Address: 18 Woodhead Road Holmfirth HD9 6PP

Application number: 2023/90444	
What is the application for?:	Erection of detached dwelling
Address of the site or building:	Land adj, Fern Bank, Far End Lane, Honley, Holmfirth, HD9 6NS
Postcode:	HD9 6RP

Type of comment: An objection	
Do you wish your comments to be published on the website anonymously?	No
We have looked at the applicants Ecological Impact Assessment dated 30th January 2023 which has only recently been added online. It raises concerns in relation to no18 Woodhead Road. The report states that 'scrub on the steeper section of the embankment, adjacent to 18 Woodhead Road, has not been cut back' – this is unlike the rest of the site. This predominantly dense, evergreen laurel hedging described as 'up to 6m in height' is within 2-3 metres of no18! This has been left to substantially overgrow by the current owners of the land. In the 30 years that we have lived at no18 these laurels have never been this high - they were managed to a reasonable height by the previous owners so that they did not overshadow no18. The applicant's report notably refers to 'bare ground beneath the heavy shade of the laurel shrubs' on the site. We

Proposed Ground Floor Plan - 1:100

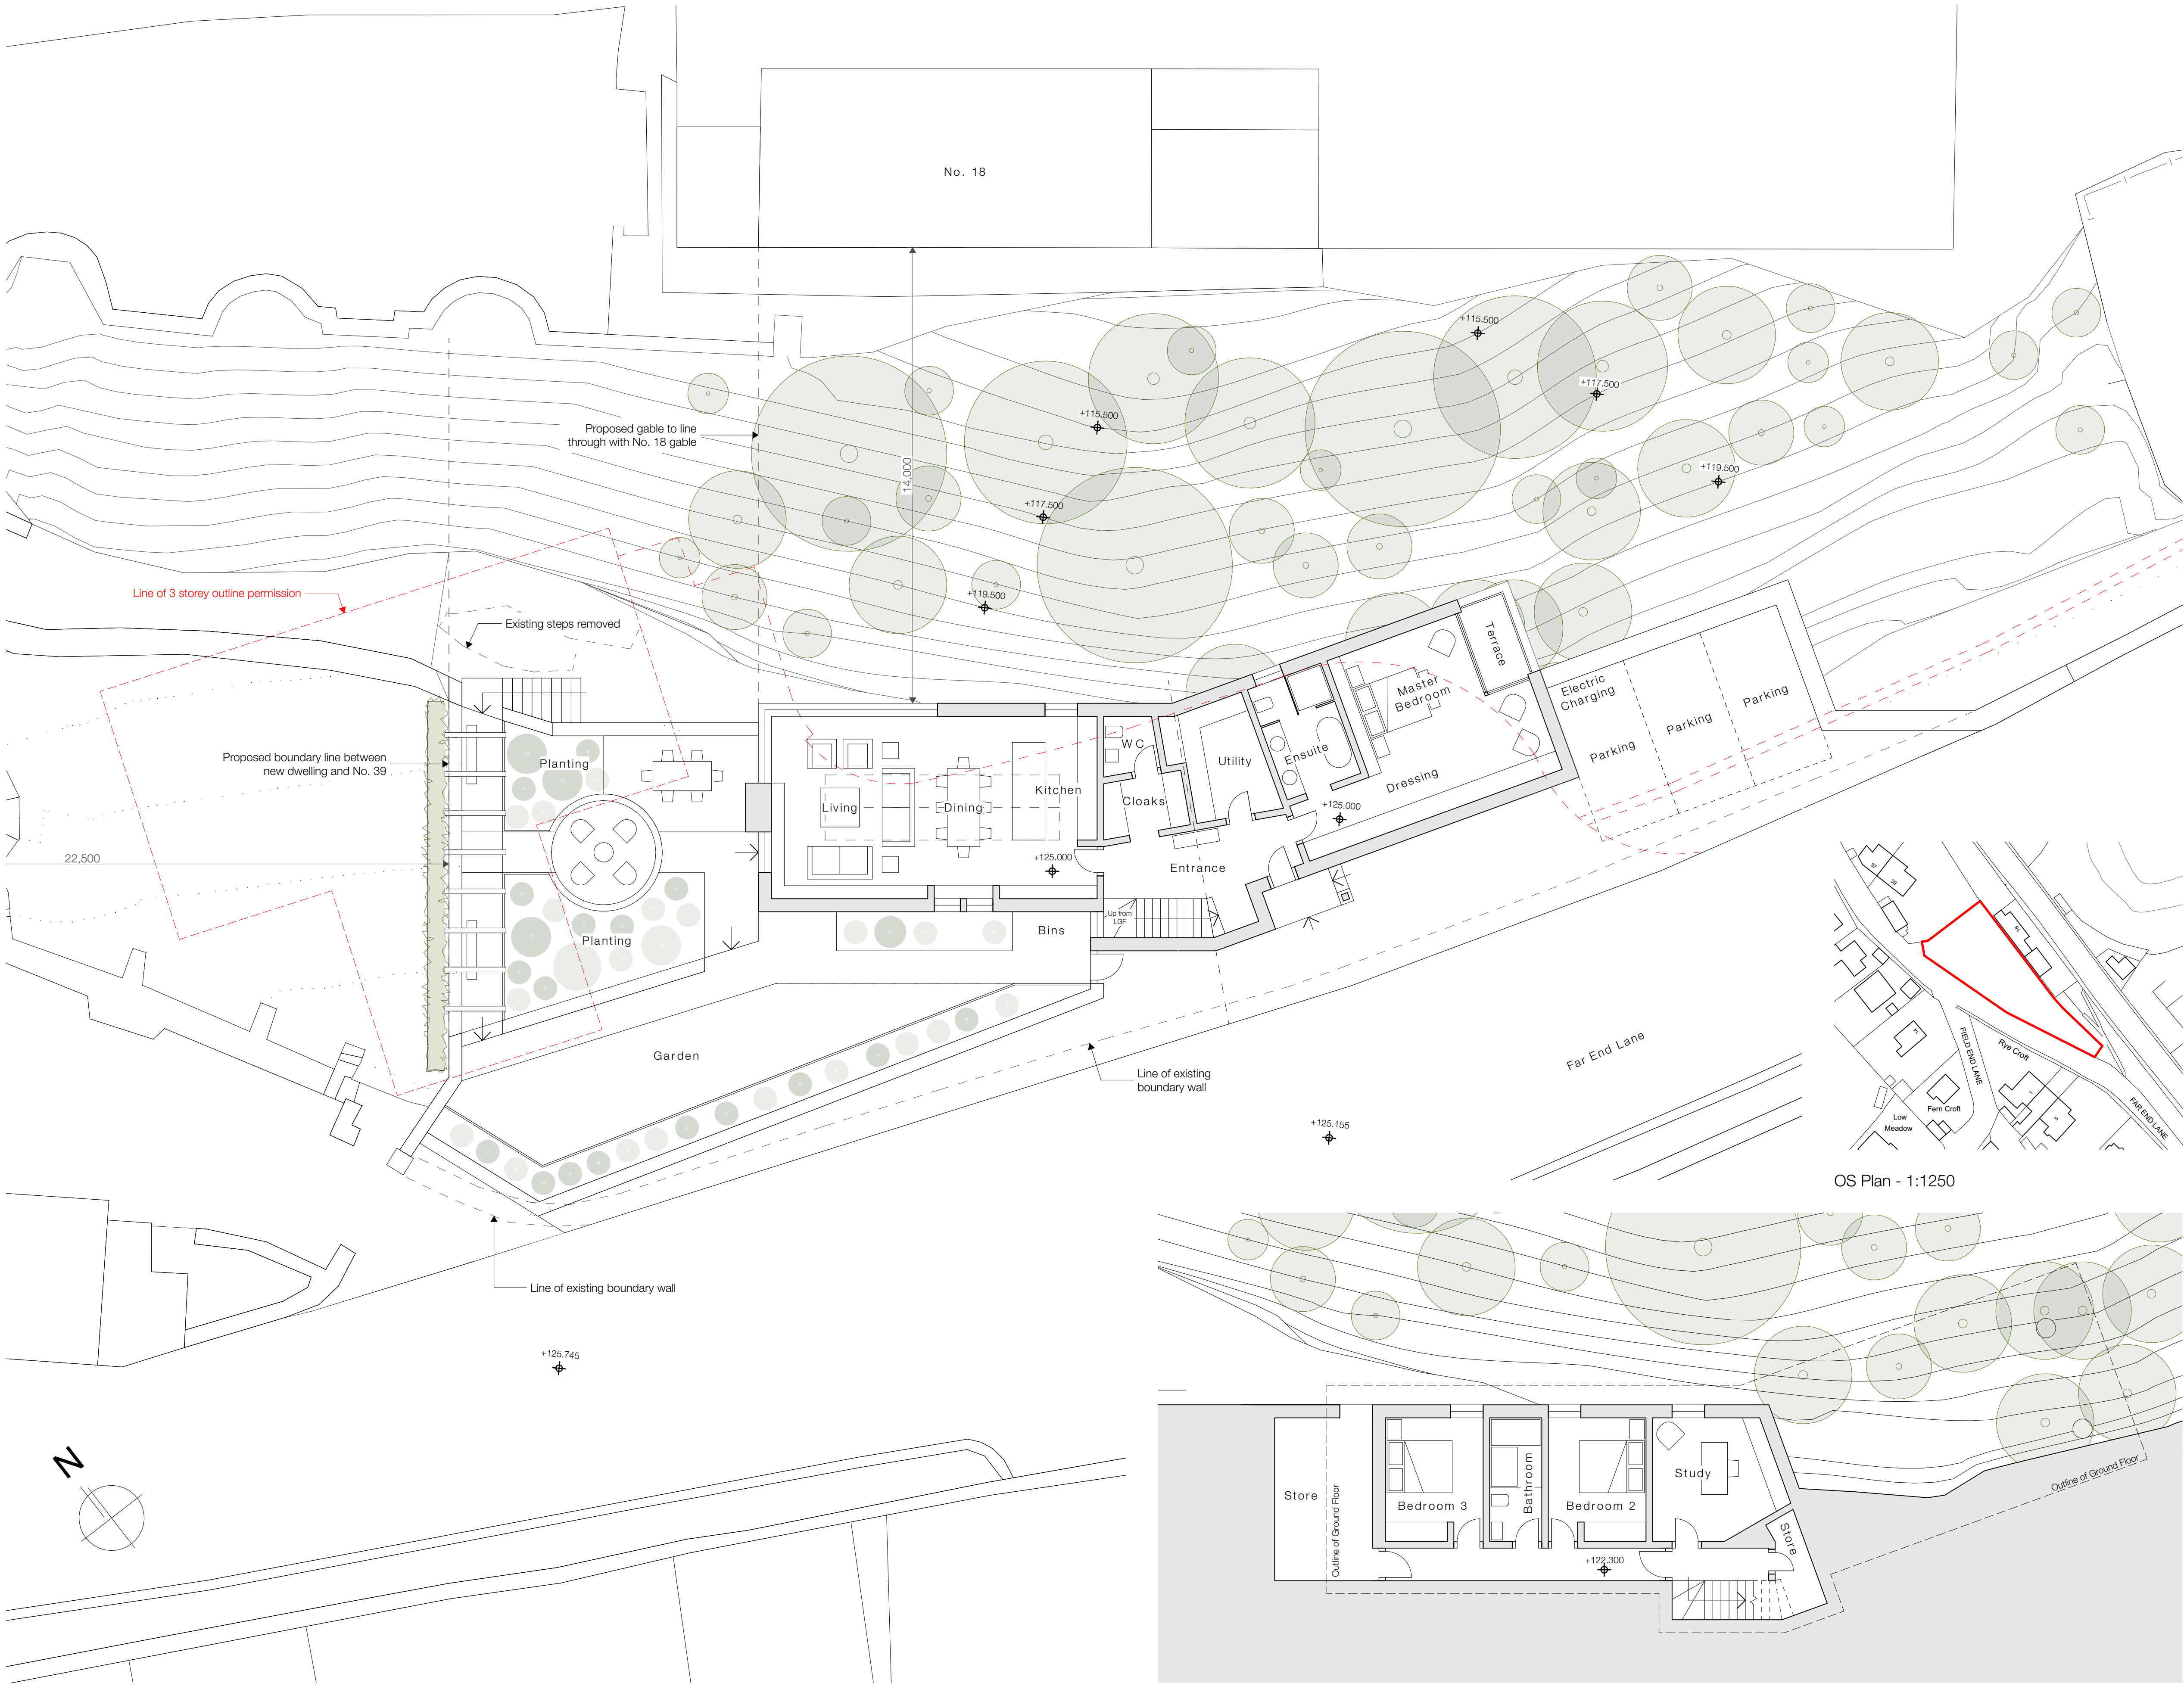
This proposal will have an overbearing impact on no18.
